STATE OF WASHINGTON
DEPARTMENT OF ECOLOGY
Central Region Office

RE: 202402833, SE-24-00021

Thank you for the opportunity to comment on the SEPA for the Johnson Ag Utility Building. We have reviewed the application and have the following comments.

CIVIL SITE PLAN

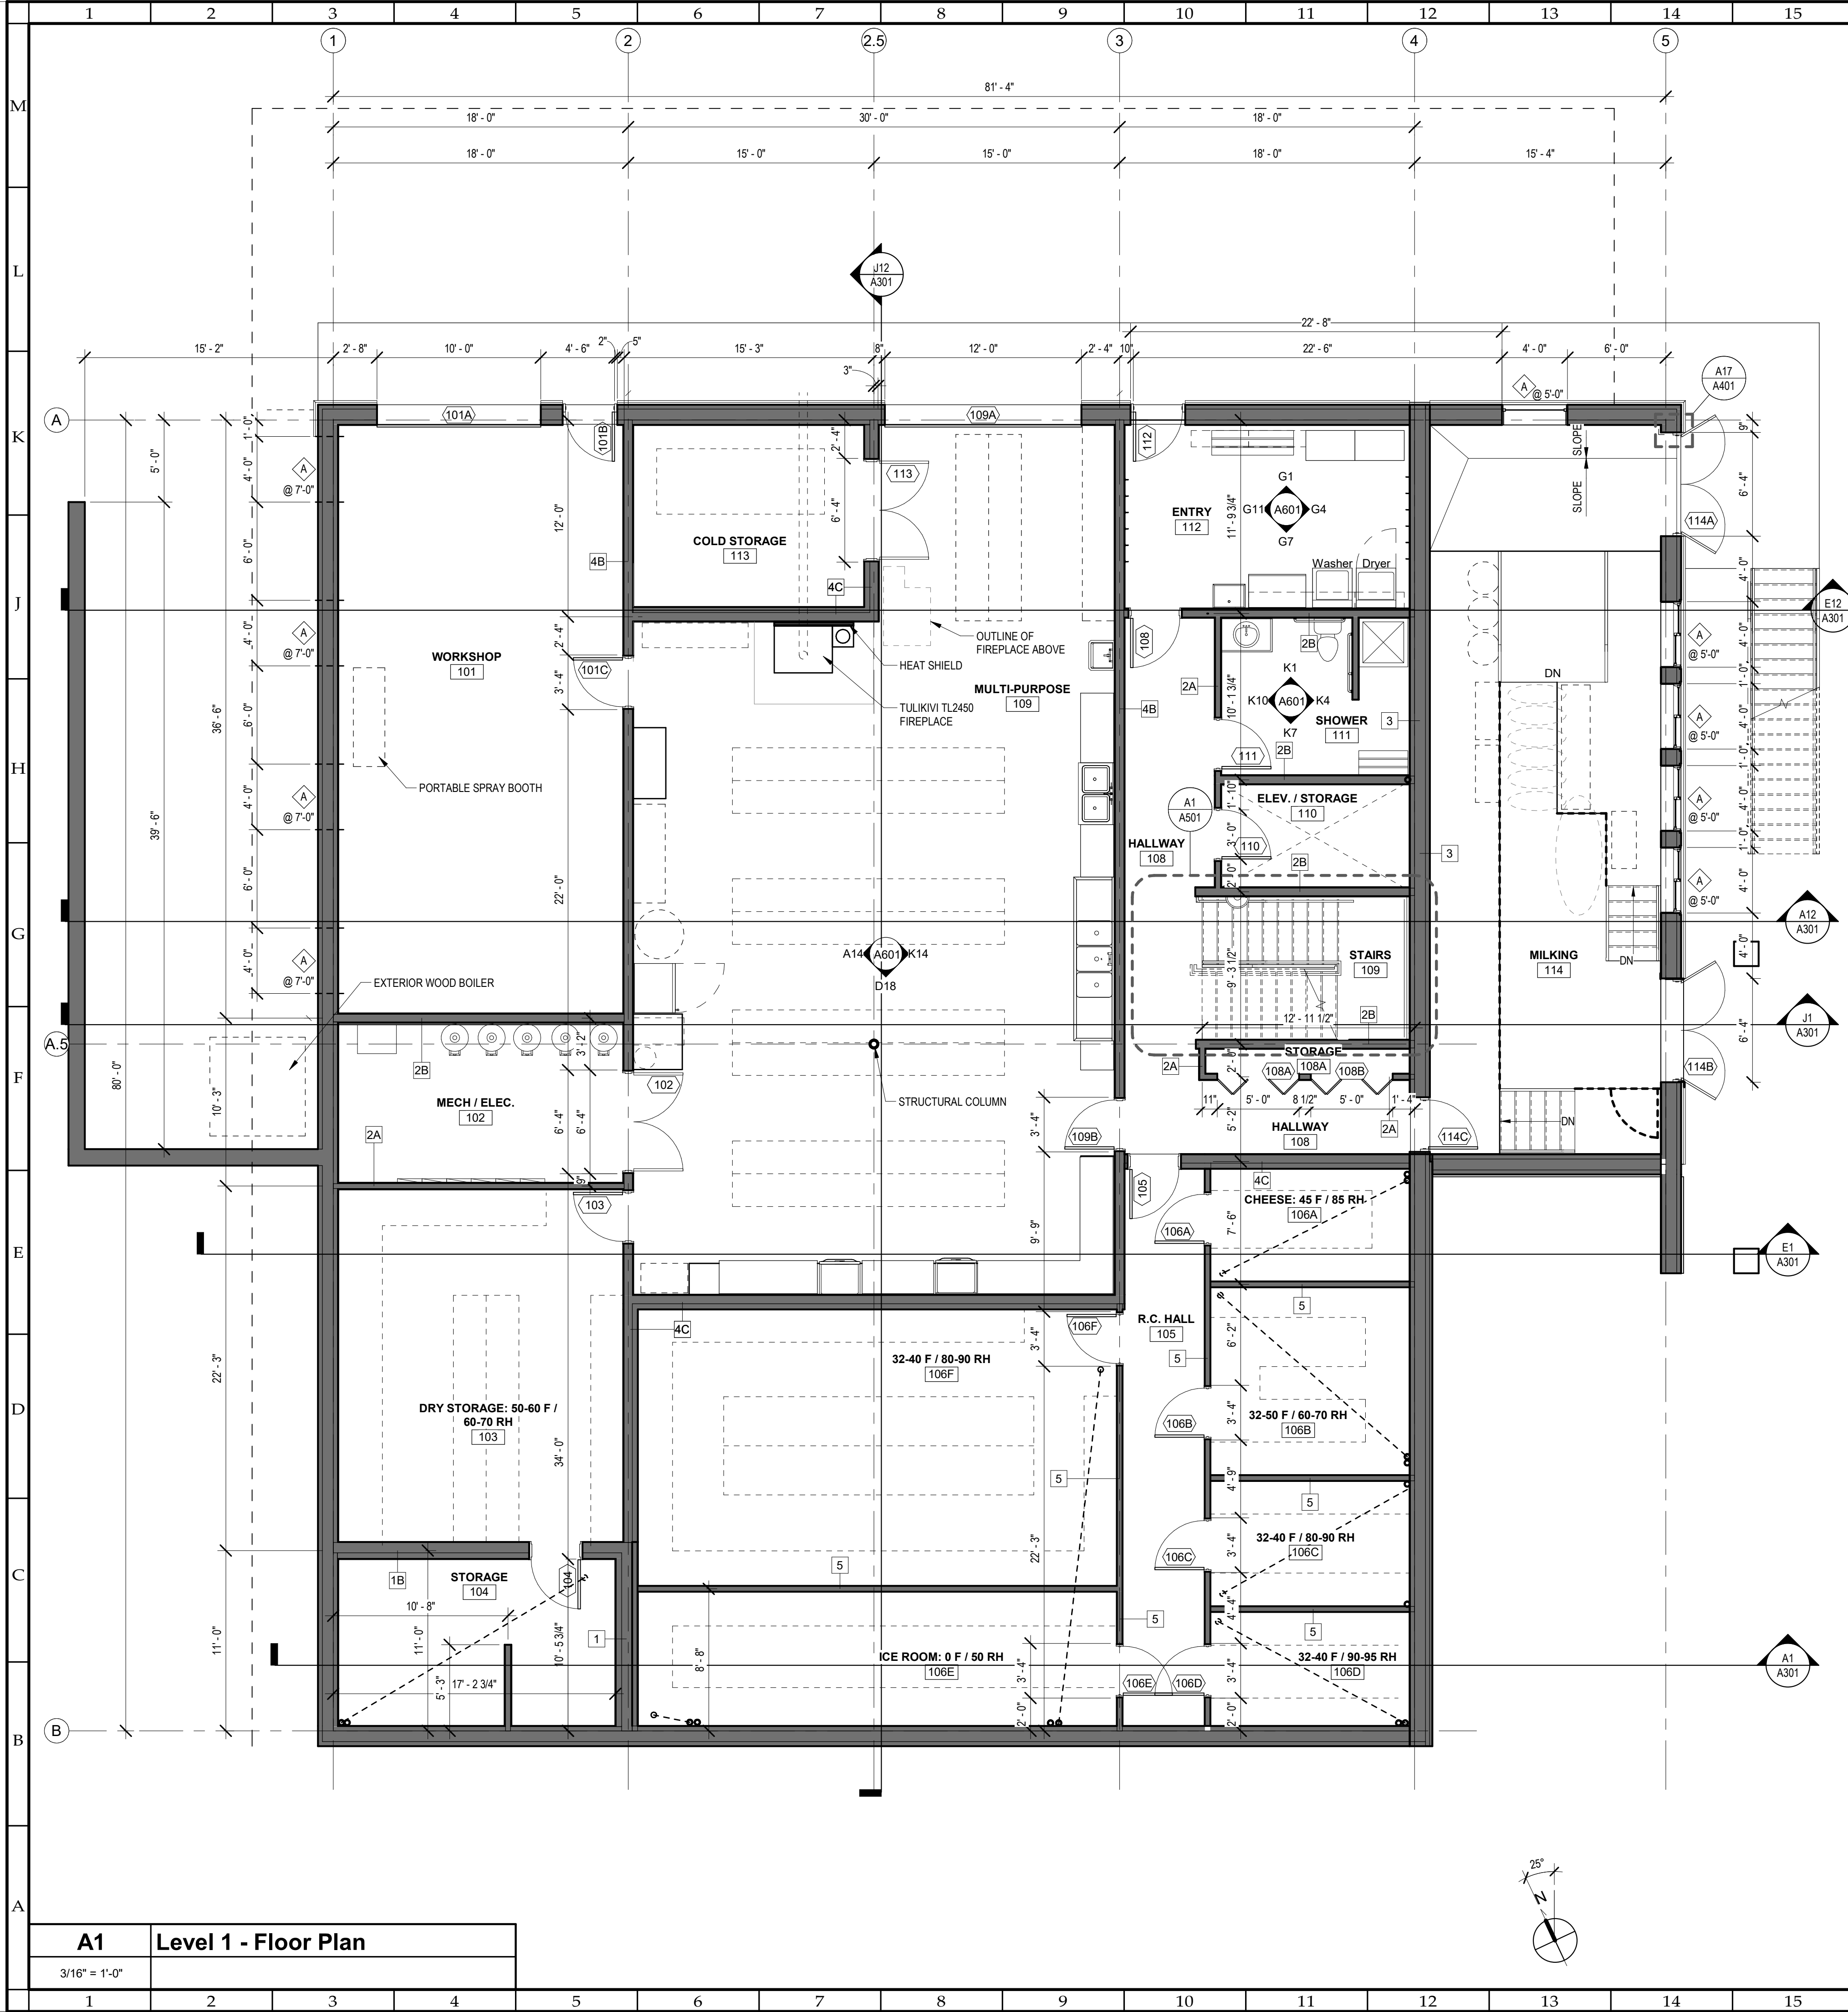
The property is located in the Rural Conservancy shoreline designation which has a buffer of 100' to the Creek. We also have concern that the site plan does not show the existing access to the construction site, nor other required information do determine if work in the buffer will be necessary to modify the existing access for construction of the new structure. If so, this work may trigger the need for additional shoreline review.
